**WELWYN HATFIELD BOROUGH COUNCIL  
EXECUTIVE DIRECTOR - PLANNING, PUBLIC PROTECTION AND GOVERNANCE**

**DELEGATED APPLICATION**

**Application No:** 6/2020/1463/FULL  
**Location:** 1 Maynard Place Cuffley Potters Bar EN6 4JA  
**Proposal:** Erection of a one storey roof extension to create no 6 flats including 3 x 1 bed and 3 x 2 bed flats, associated parking and cycle and refuse provision.  
**Officer:** Ms Clare Howe

**Recommendation:** Refused

Proposed Block Plan
1:500 @ A3

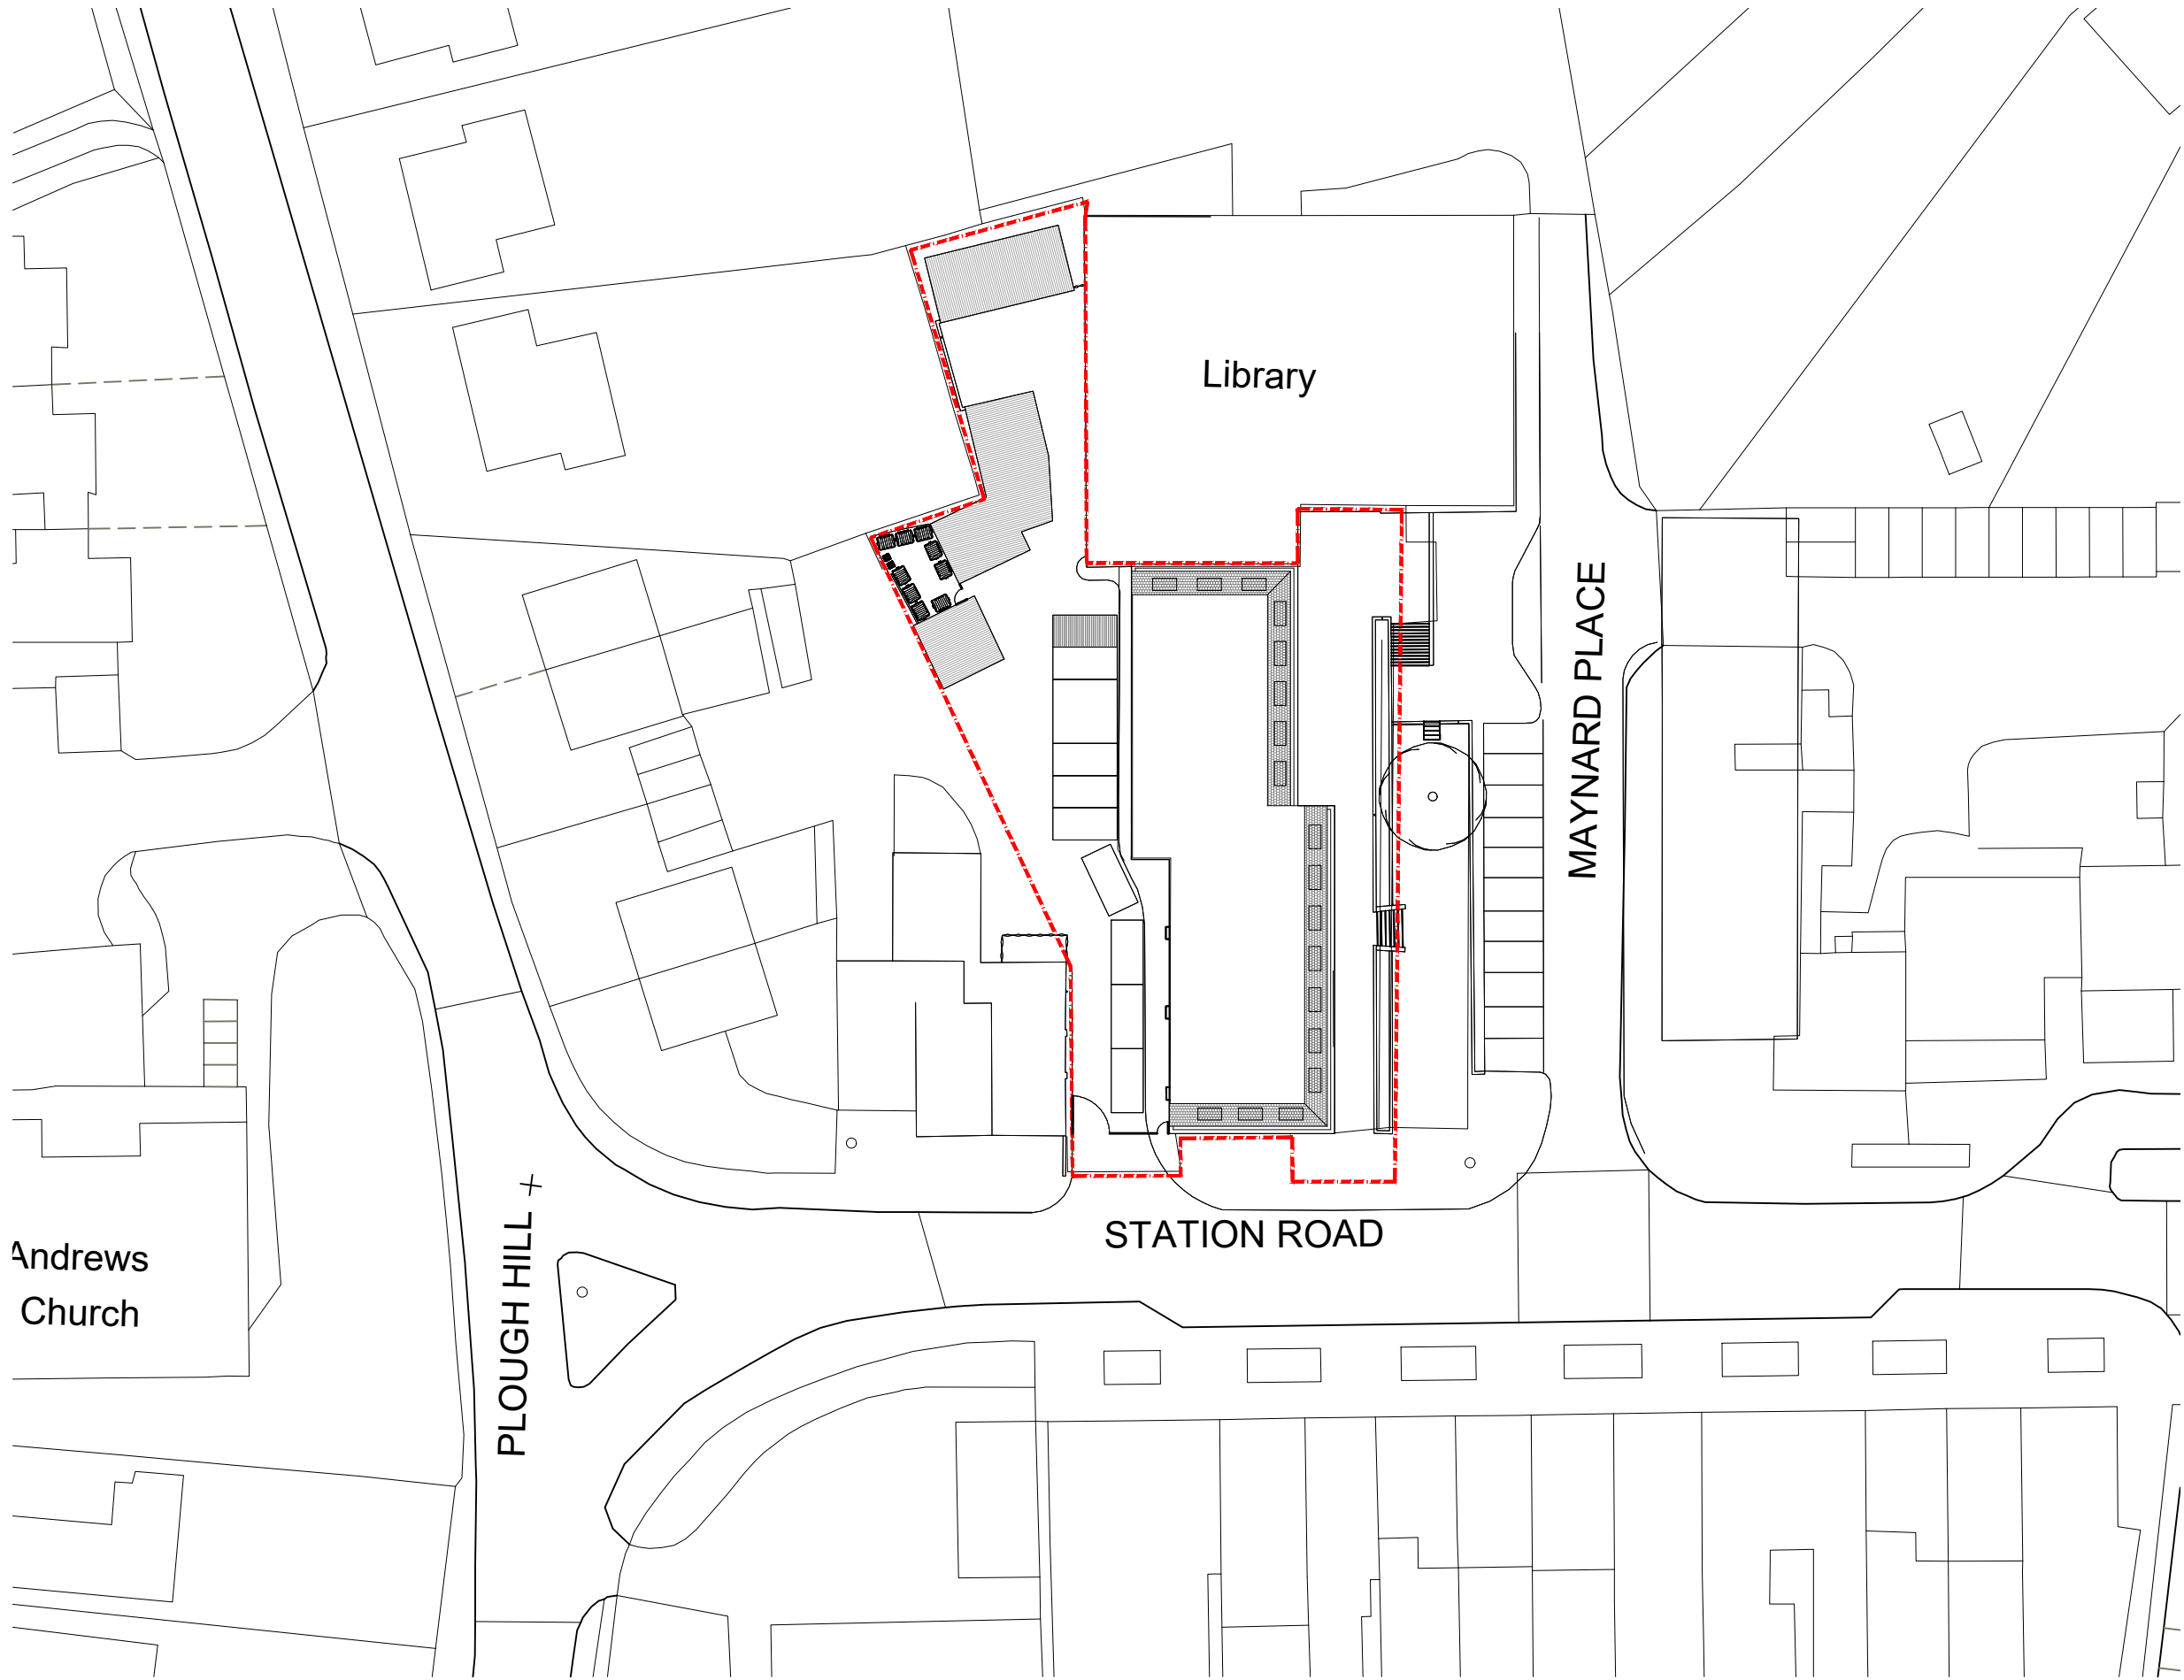
The bin stores, cycle parking and car parking are also located to the rear of the site. The application has been supported by a block plan showing the proposed car parking layout. Concern was raised by the Highways Authority regarding the car parking layout. In response to the concerns raised the applicant's Transport Consultant has provided further information, including a car park swept analysis and written responses to points raised. These will be

In terms of this application there is no car parking proposed, and the applicant is reliant upon the existing car parking courtyard layout to provide provision for car parking for the development. In doing so, he proposed development does not seek to present any additional car parking and would result in the loss of 4 car parking spaces to provide space for cycle parking, a visitor space and a double space for delivery vehicles. As the existing spaces are not allocated and will be shared between the existing and proposed apartments, the assessment needs to take into consideration the whole site, not just the additional proposed units. The development would therefore reduce the amount of car parking available from 21 to 17 car parking spaces and would not provide the required 8 parking spaces for this new development. The development would therefore result in an additional pressure upon the existing car parking scenario.

This development proposes 17 car parking spaces (2 marked as disabled bays) for the 20 flats, excluding the visitor bay and two spaces for deliveries. Car parking bays 1 to 4 would however fail to comply with Manual for Streets 8.3.48, which states '*for parking parallel to the street, each vehicle will typically need an area of about 2m wide and 6m long*'. The transport consultant had commented that the proposal utilises the existing spaces and garages rather than provide a new reconfigured car parking. Further to this, within the Transport Statement it states that "Plate 7 reiterates the existing arrangement with garages and areas where residents' cars were parked during a site visit undertaken by the team, and therefore considered to be realistic parking spaces." Having checked the planning records obtained by the Local Planning Authority on this site, and minded that the Transport Statement states these spaces are identified due to cars parking in unallocated location, it is reasonable to conclude that the spaces identified within the Block Plan as existing spaces, have not been agreed through the formal planning process. These spaces are of an unacceptable standard and the justification that this is the current scenario is not accepted. As 4 of the spaces are considered

unacceptable, there would be a total of 13 car parking spaces serving 20 flats. The development would therefore provide 45% of the maximum car parking provision. As the development falls within zone 4, this is considered unacceptable.

<p><b>Conclusion</b></p>	
<p>To conclude on the above the proposed development provides no additional car parking resulting in there being 13 spaces for 20 residential units, within a Zone 4 location and therefore lacking 16 car parking spaces to satisfy the SPG. To conclude on the above, the development does not propose any additional onsite car parking and would result in there being 13 spaces for 20 residential units, within a Zone 4 location, therefore being 16 spaces short to satisfy the SPG. In regards to the justification provided this is not considered sufficient. The development therefore fails to provide sufficient onsite car parking and would result in cars dispersing onto the nearby highway leading to congestion and safety issues within the wider road networks. Overall the development is of a poor design and provides an insufficient amount of car parking contrary to Policies D1 and M14, the Car Parking Standards and the Framework.</p>

Proposed Third Floor Plan  
 1:200 @ A3

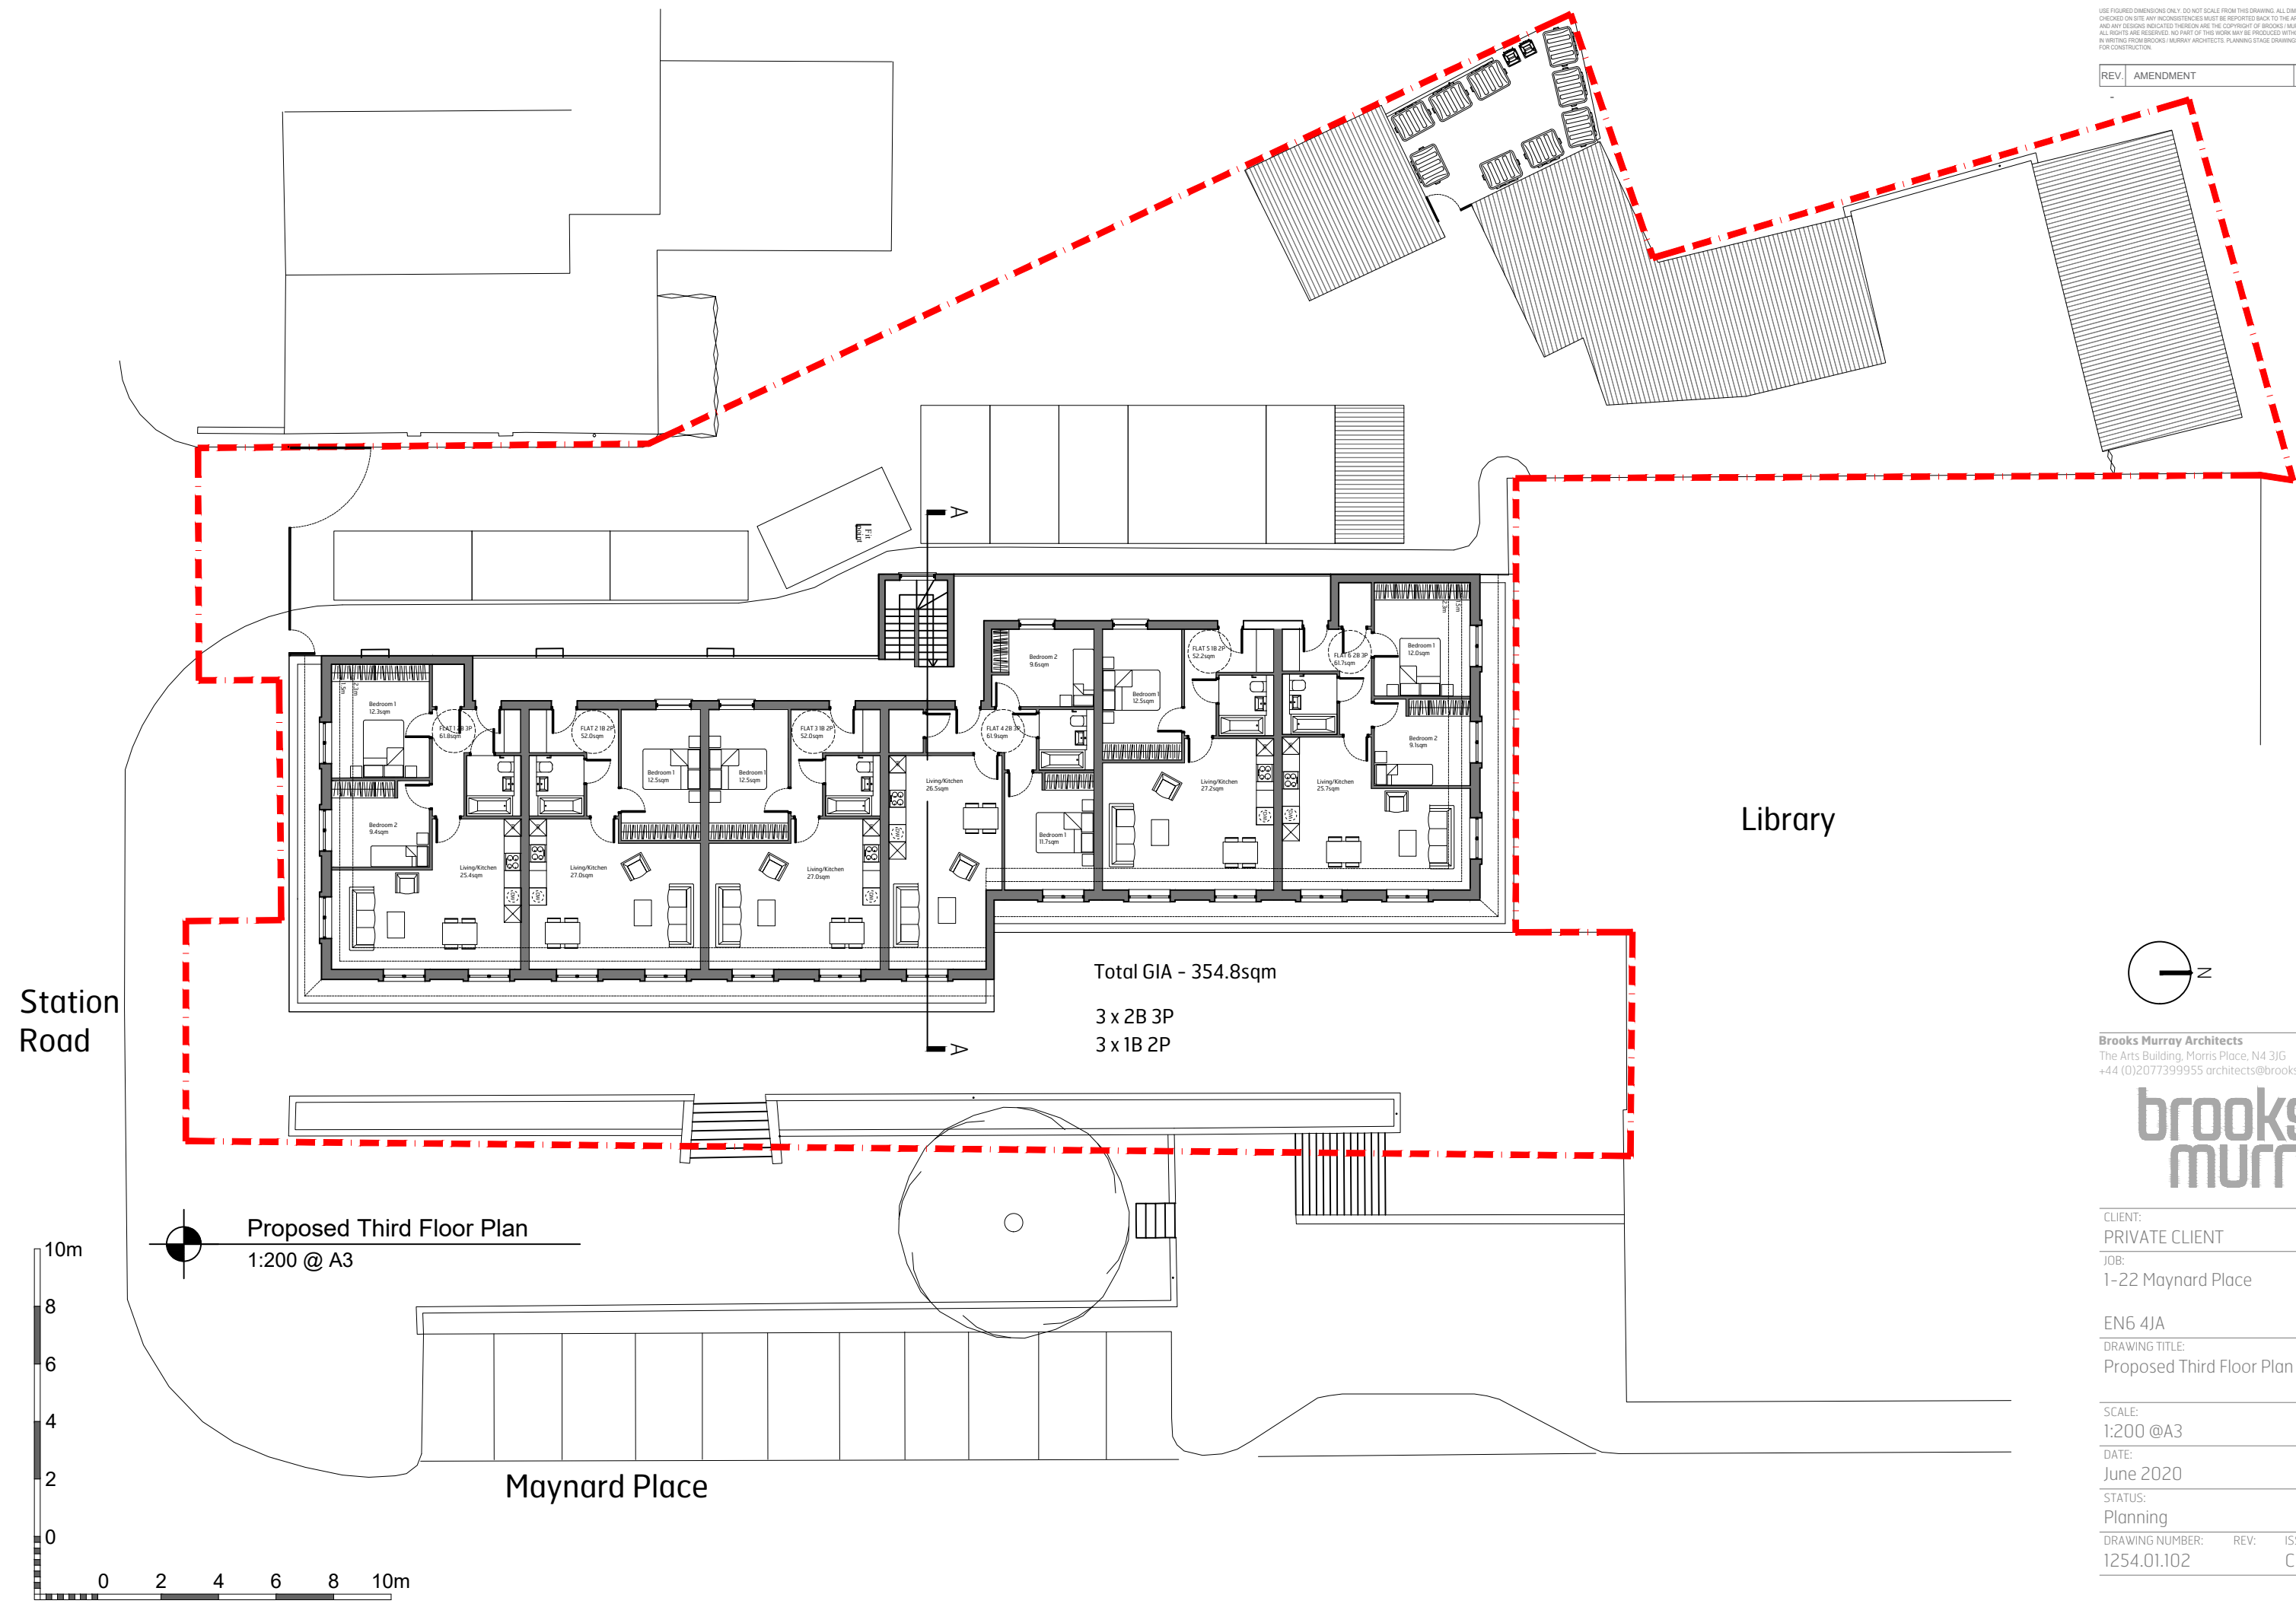
The site is located in the centre of the settlement and would extend above the existing apartments. The development is designed with a mansard roof, with dormers installed on the front and side elevations. The proposed development would result in the building becoming 4 storeys high. When approaching the site from the east towards St Andrews Church there is a slope upwards in topography, creating a gradual incline in roof height. As shown within the Design and Access Statement, the increase in roof height would not compete with the height of St Andrews Church.

In terms of appearance, traditional materials are proposed, including red brick and a white parapet to match existing. The hipped mansard roof would be finished in grey slate tiles, similar to those within the wider street scene. The dormer windows would be grey aluminium with white frames, to blend in with the grey slate tiles. The success of the development will rely on the quality of the materials. It is therefore considered reasonable and necessary, for the avoidance of doubt, precise details/samples of the external materials will be secured through a planning condition. To ensure the materials are of a high quality a condition shall be applied requiring the agreement with the Local Planning Authority.
